RE: Resubmittal of ESC Plan SWQ-2025-00057 | Comment Response Letter

The following memo provides responses to SWQ staff comments for Target ABQ W Erosion Control and Sediment Plan located at St. Joseph's Dr NW between Coors Blvd NW and Atrisco Dr NW on November 21st, 2025. Staff comments are in *italic* followed by the Applicant responses that are in **red and bold**.

SHEET NUMBER  
**C301**

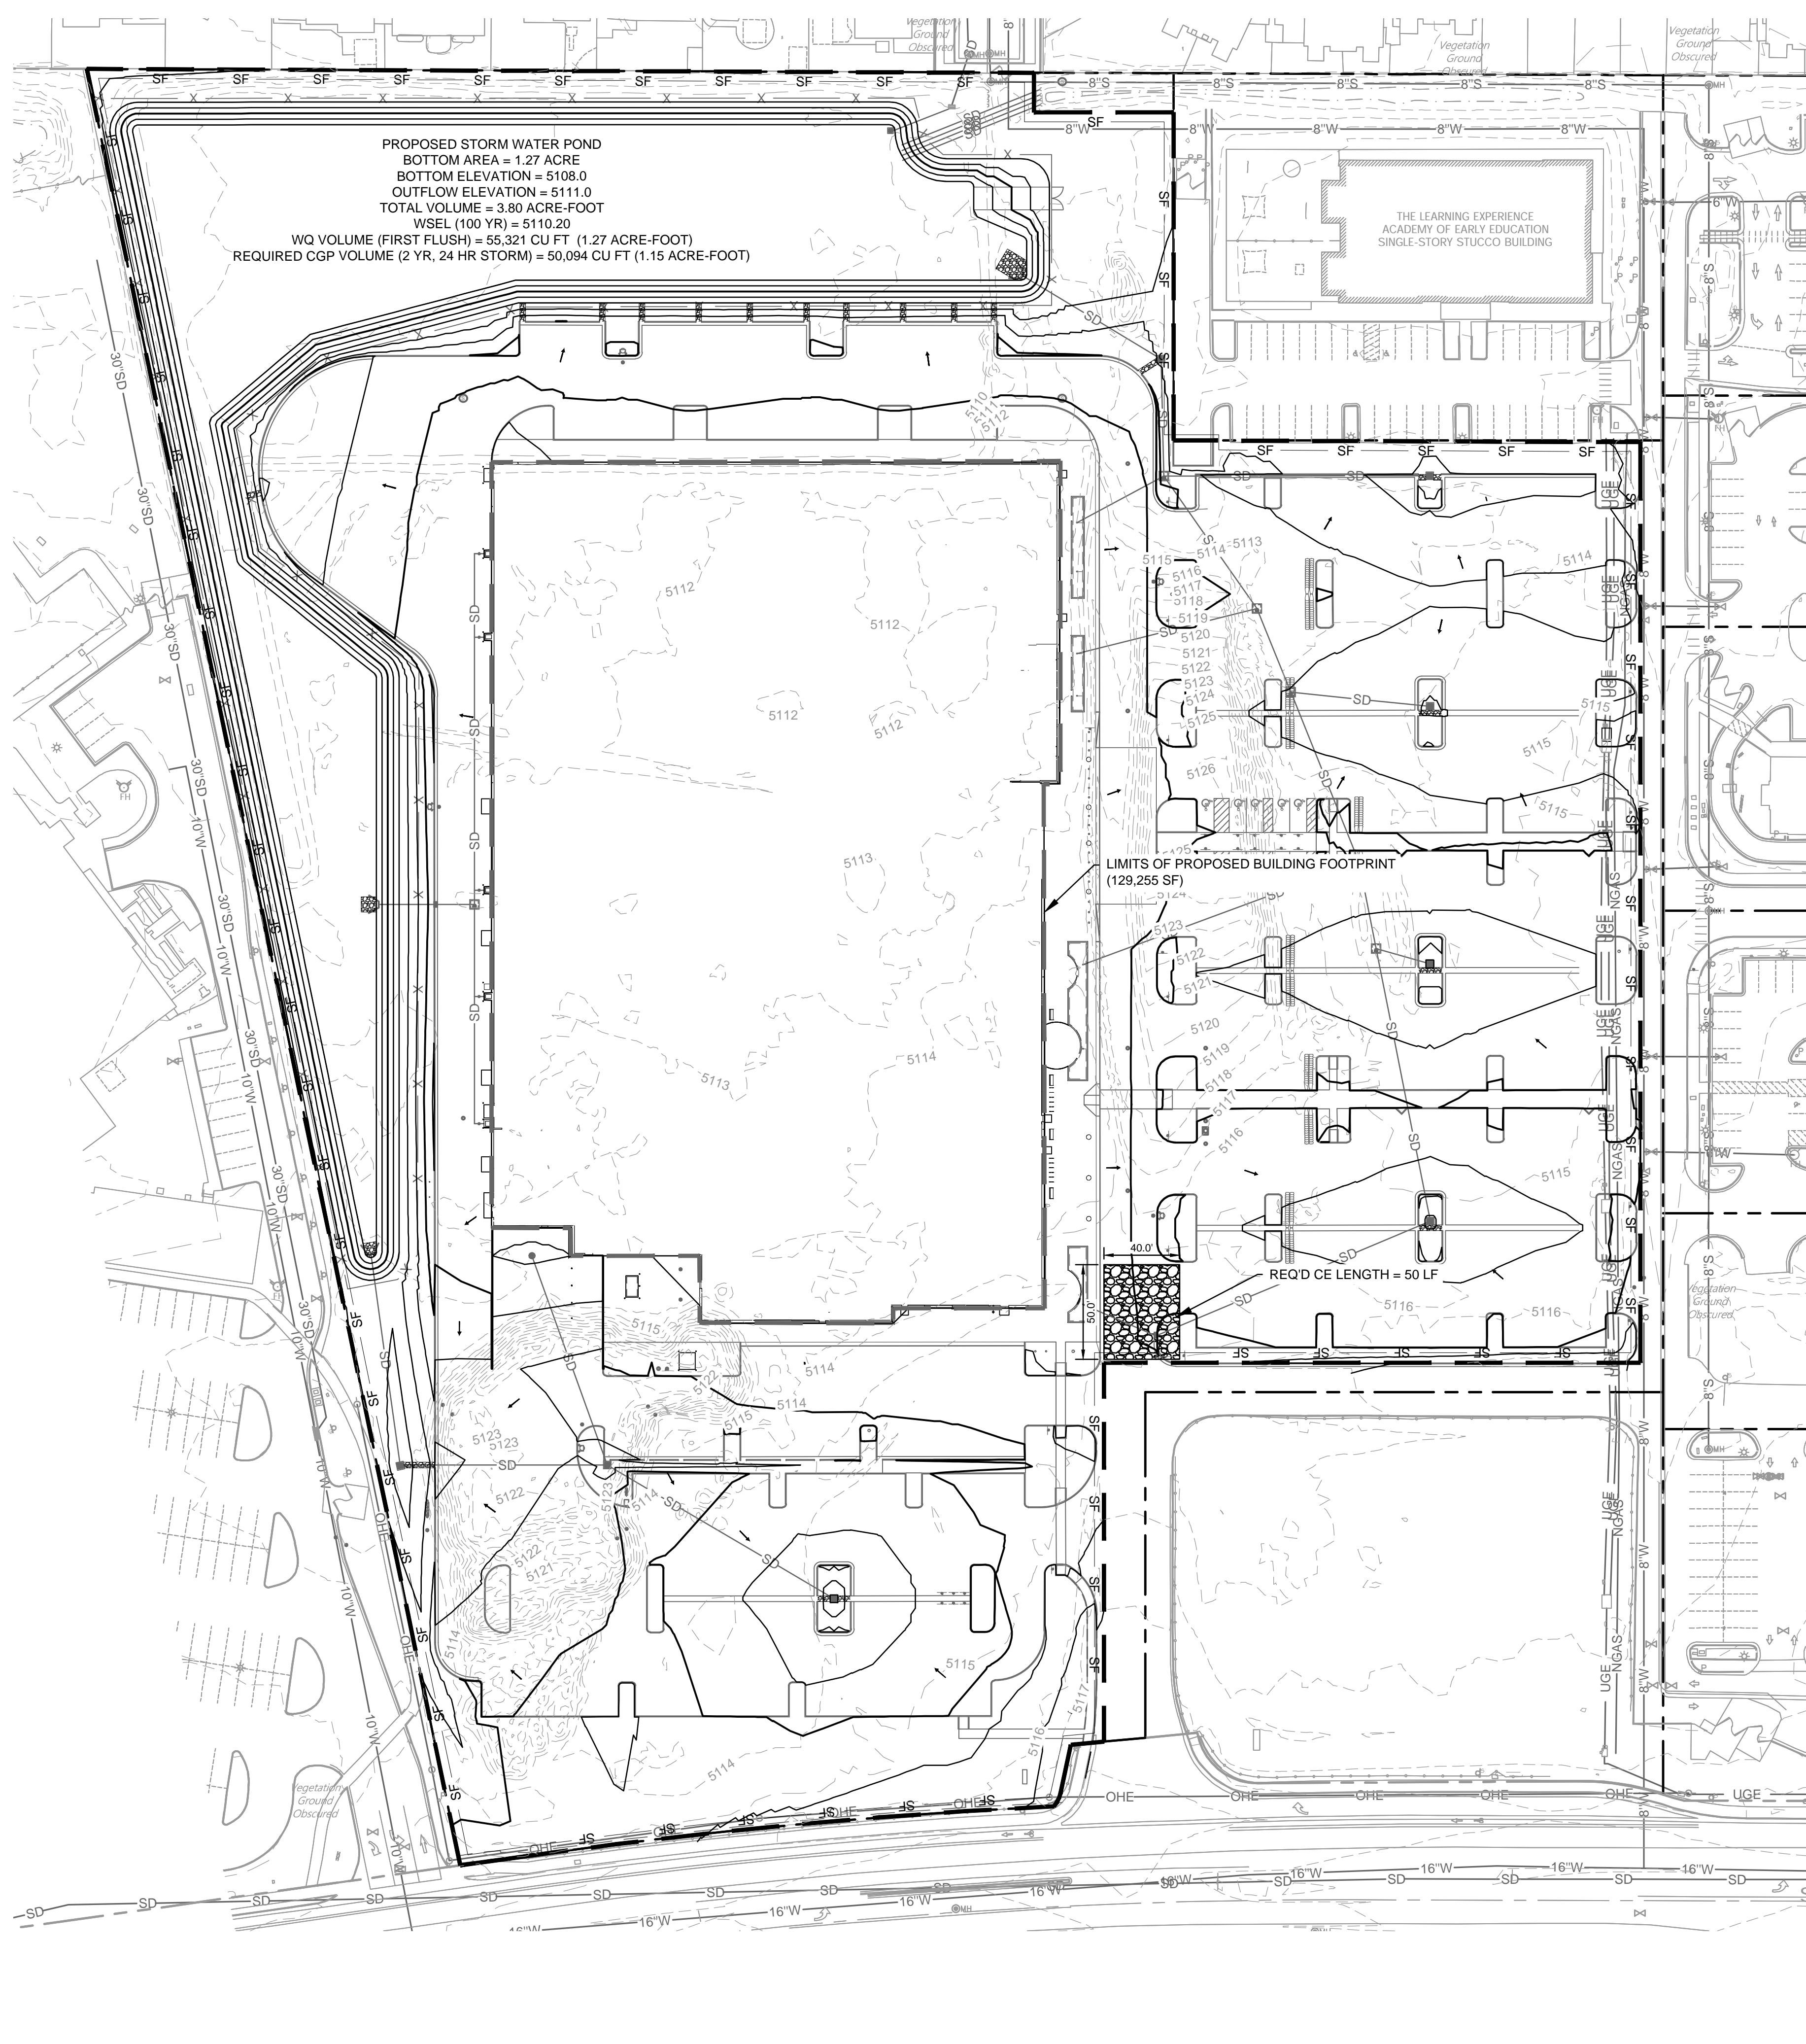
2. *Identify locations of concentrated flow paths that enter and exit the disturbed areas. Show on-site drainage patterns of stormwater before and after major grading activities. CGP 7.2.4.f.*

Include design volume calculations using the conic method and 100-year hydraulic calculations for the outlet on the ESC Plan with the details. Add bold construction notes for the Sediment Basin, indicating that riser modifications and excavation of the additional pond volume are the first construction tasks to be completed before placing any fill in the existing pond.

5. The Site Data and Albuquerque ESC Notes are not legible on sheet C300 & C301. The Albuquerque ESC Notes are out of date. Update the notes and ensure all text is legible.

Applicant Response: Location of concentrated flows have been identified on added sheet C304. On-site drainage patterns of stormwater before and after major grading activities are shown on sheets C300 & C301.

Applicant Response: Design volume calculations added to sheet C303. Construction notes for the Sediment Basin(indicating that riser modifications and excavation of the additional pond volume are the first construction tasks to be completed before placing any fill in the existing pond) are shown in red, bold, & underlined on sheets C300 & C301.

Applicant Response: All notes have been updated and increased in size to be more legible. Albuquerque ESC notes have been updated.
